3 2025 0133 Loft Shay Farm Clitheroe Road Ribchester PR3 2YQ

Subject: 3/2025/0133 Loft Shay Farm Clitheroe Road Ribchester PR3 2YQ

**Proposal** Change of use of land to form extended residential curtilage. Proposed detached garage to include solar panels and living accommodation above. Insertion of second floor side facing windows to main dwelling.

Proposed Site Plan

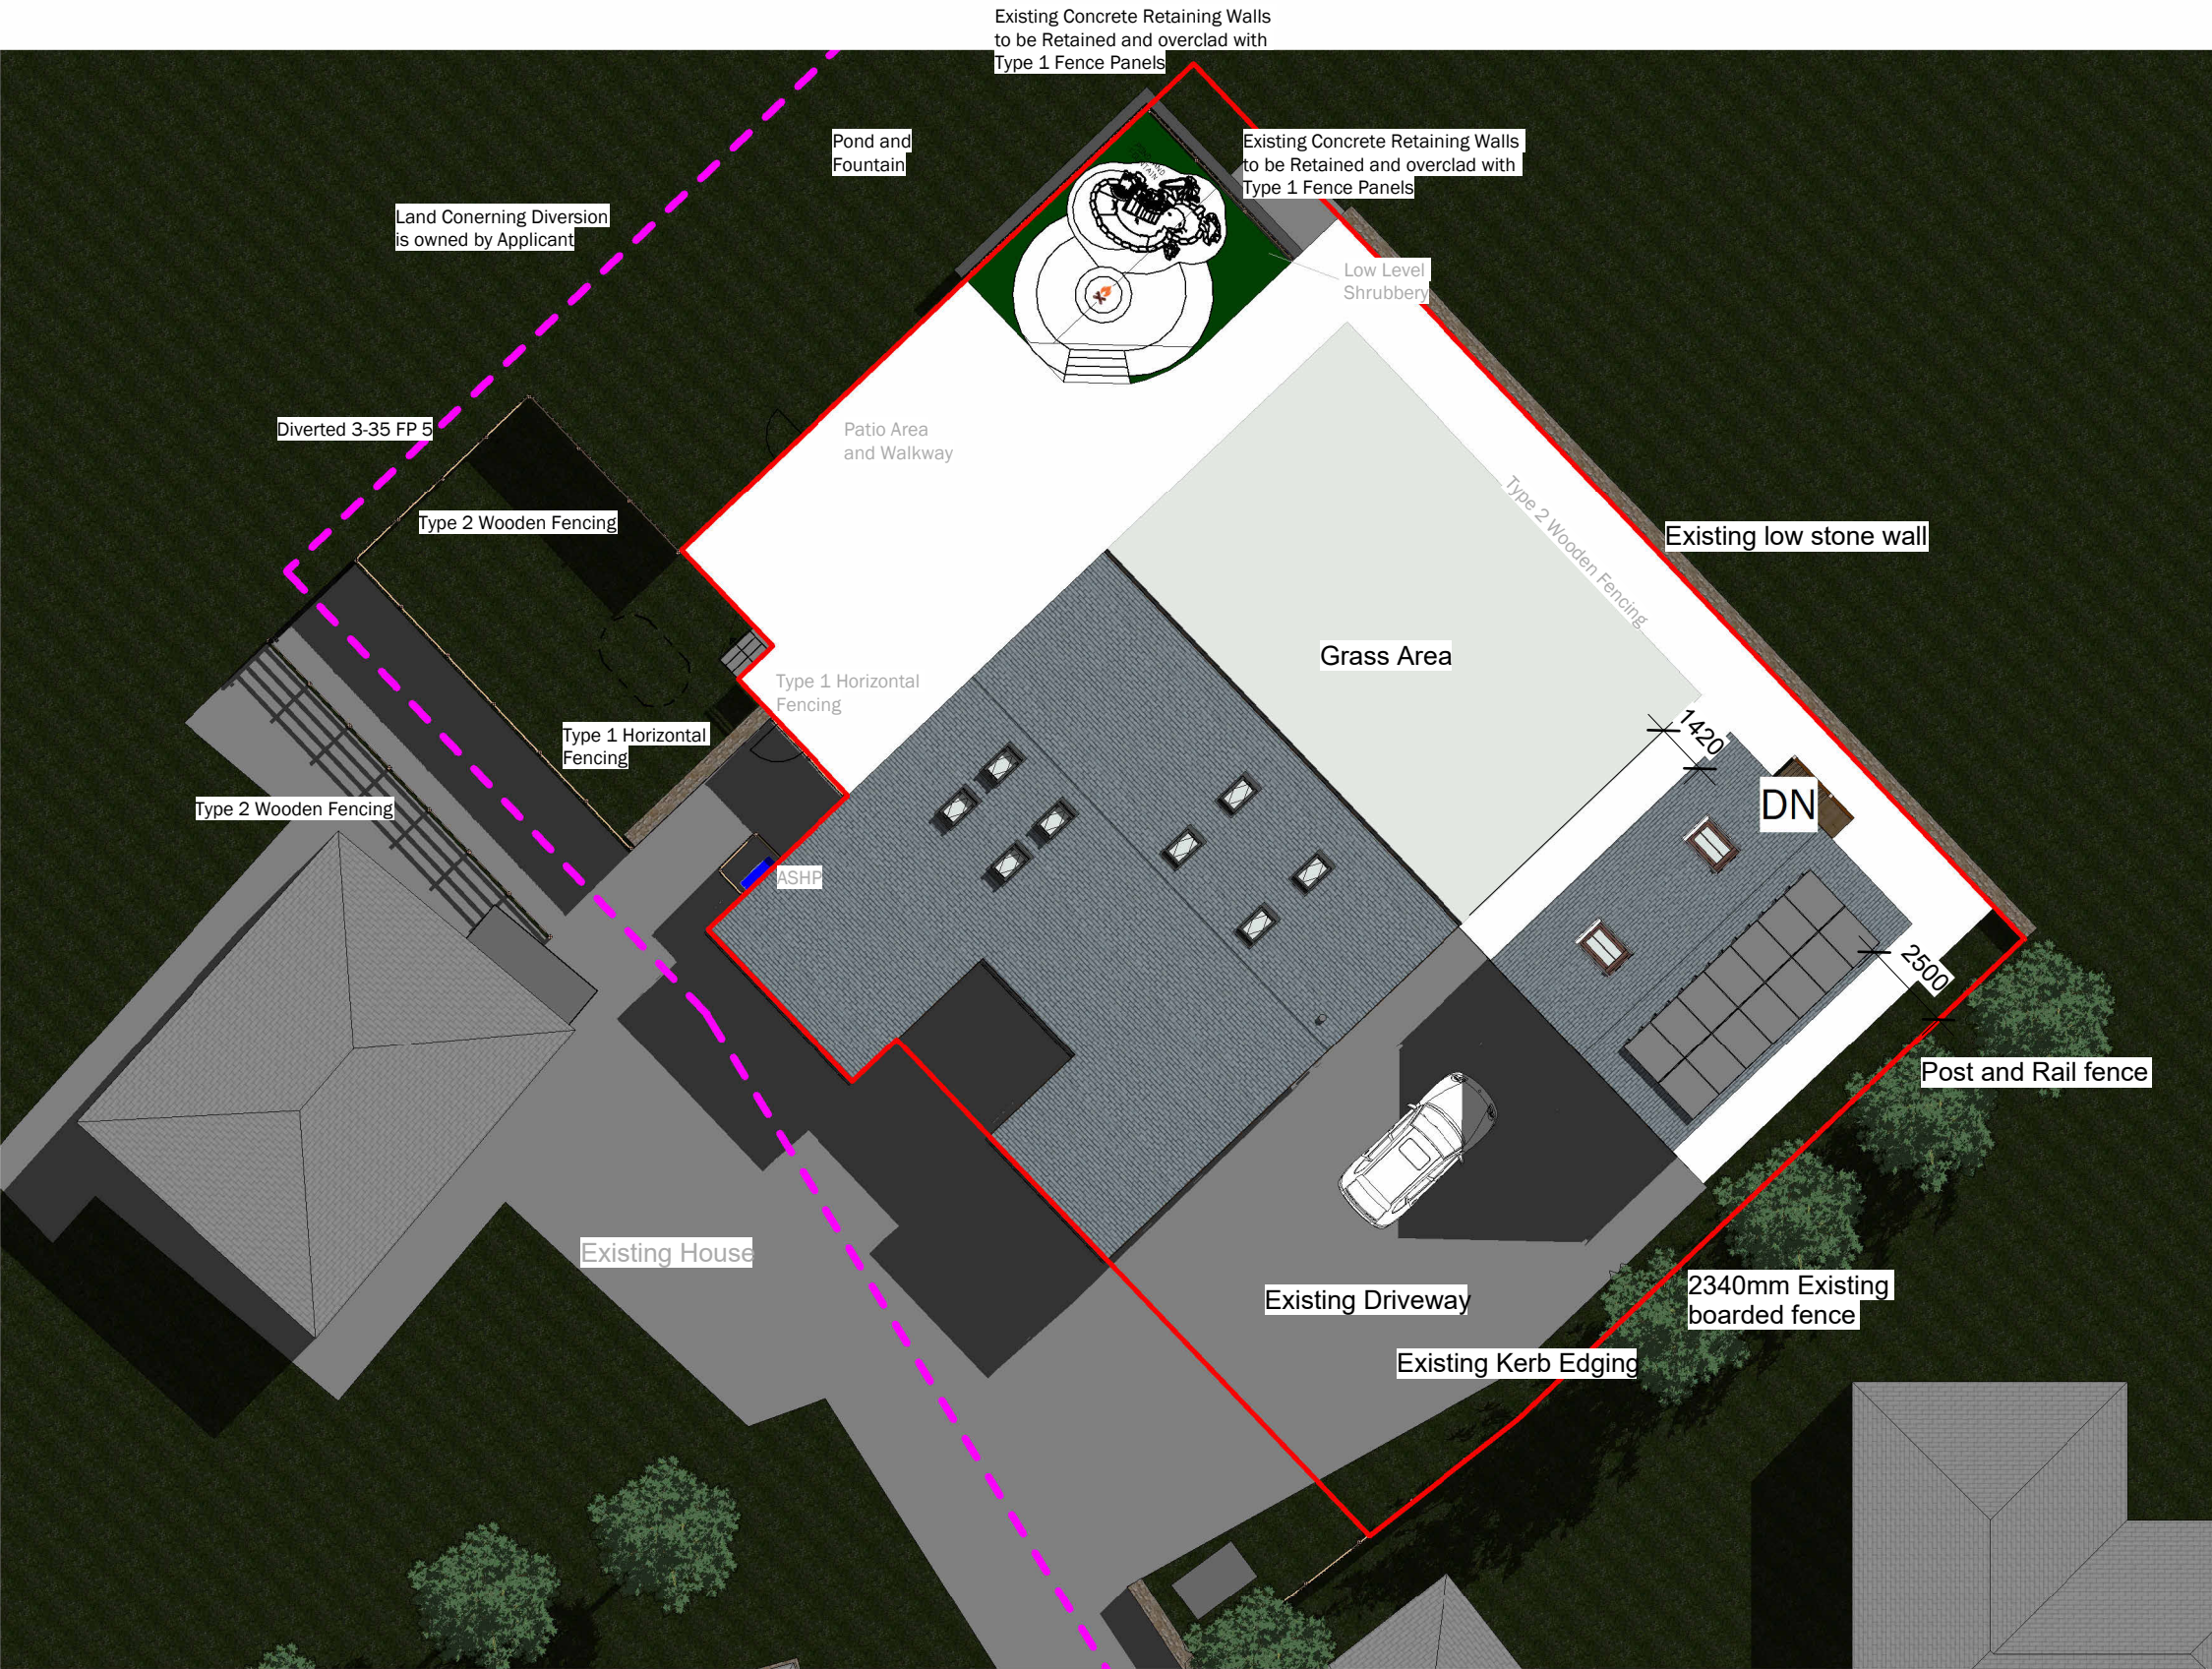
The proposed fencing will obstruct footpath FP0335005, as shown on the attached overlay, requiring a Public Path Order under the provisions of the Town and Country Planning Act 1990 Section 257 (TCPA90 S257). TCPA90 S257 orders are administered by the authority that is considering, or has granted the planning permission, in this instance Ribble Valley Borough Council.

The detail of the exact alignment of the new route, the construction specification and any association works would need to be agreed with the Public Rights of Way Team before the necessary TCPA90 S257 Order is made. I can advise that the new route must have a minimum width of 2 metres, have a firm constructed surface with no gates or stiles crossing the new route. If required for stock control the limitation of a kissing gate to BS 5709:2018 standards would be permitted.
